DOC17/312008-04
SSI7400 mod 1

**Sydney Metro City and Southwest (Chatswood to Sydenham) Modification 1 - SSI 7400
Request for EPA Comment**

I refer to the request from the Department of Planning and Environment (DP&E) to the Environment Protection Authority (EPA) dated 7 June 2017 to undertake a review of the proposed modification to the Sydney Metro City and Southwest (Chatswood to Sydenham) rail project SSI7400 Mod 1.

Figure 6 Victoria Cross Noise Catchment Areas (labelled with letters) (Source: Victoria Cross Station and Artarmon Substation Modification Report, TfNSW 2017)

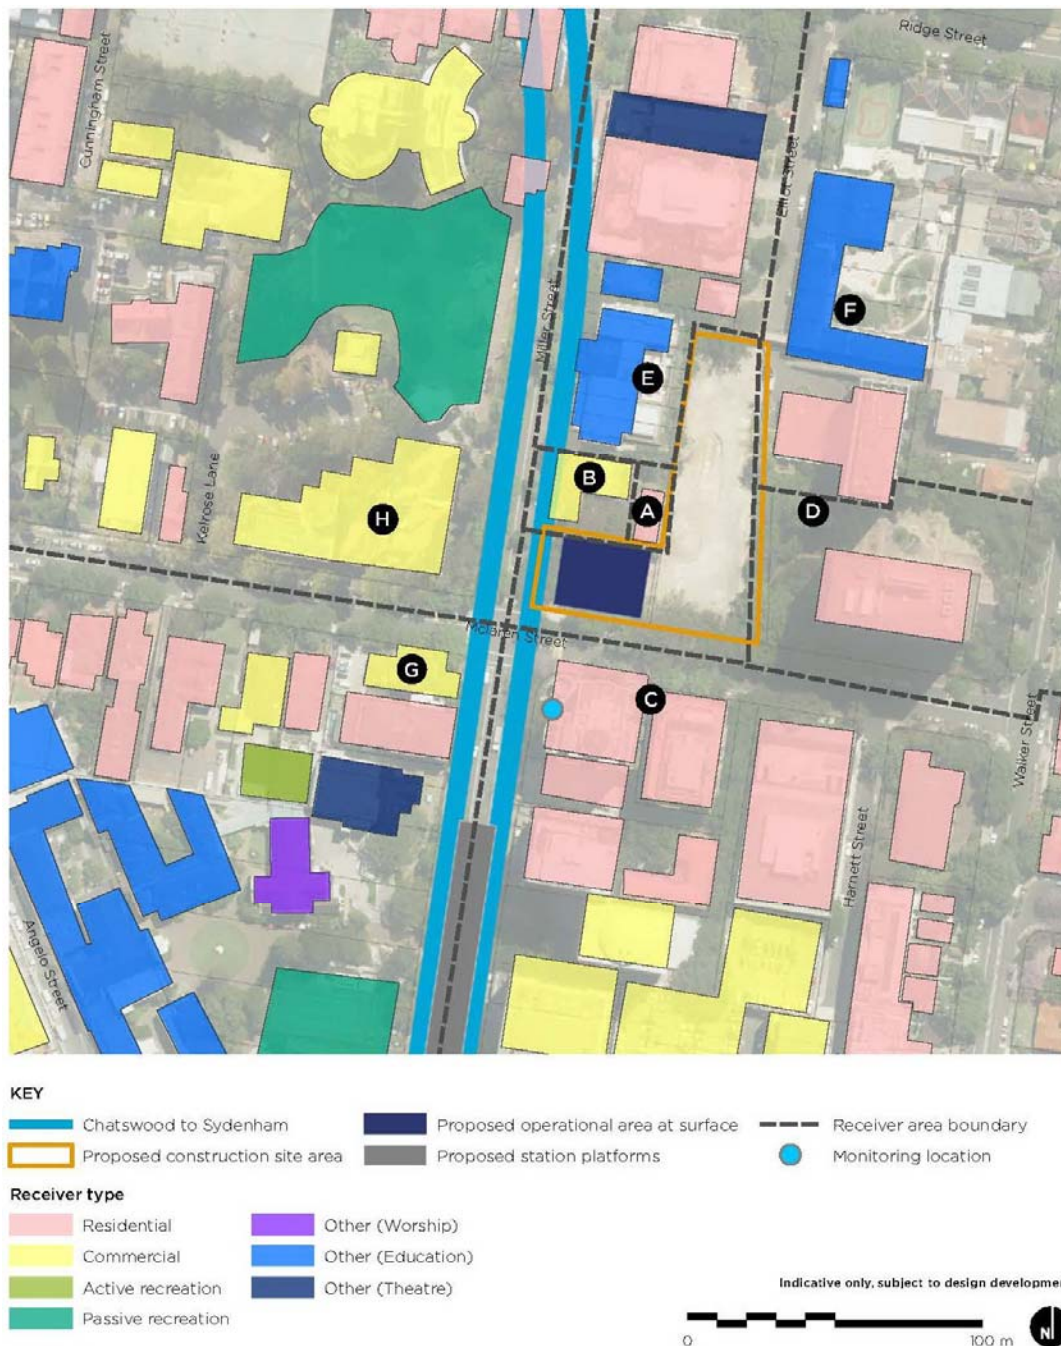
Noise Management Levels (NMLs) for noise sensitive locations near the proposed works are based on monitoring results from a location immediately adjacent to Miller Street. Miller Street appears to be a busier road than McLaren and Walker streets, which are the streets adjoining some of the noise sensitive locations near the proposed works. Background noise levels at other noise sensitive locations are therefore likely to be lower, particularly those locations to the east and north of the proposed construction site area. The proponent should evaluate the potential for this and make any necessary adjustments to the NMLs.

In relation to predicted ground-borne noise impacts in Table 10-14, the summary of results includes that the NML is exceeded by 2dB at residences in Area A during the night-time for rock drilling. A statement then follows that rock drilling could therefore operate 24 hours per day without ground-borne NMLs being exceeded, which is a direct contradiction of the previous statement. The proponent should clarify ground borne noise levels for rock drilling, at residences in Area A during the night-time.
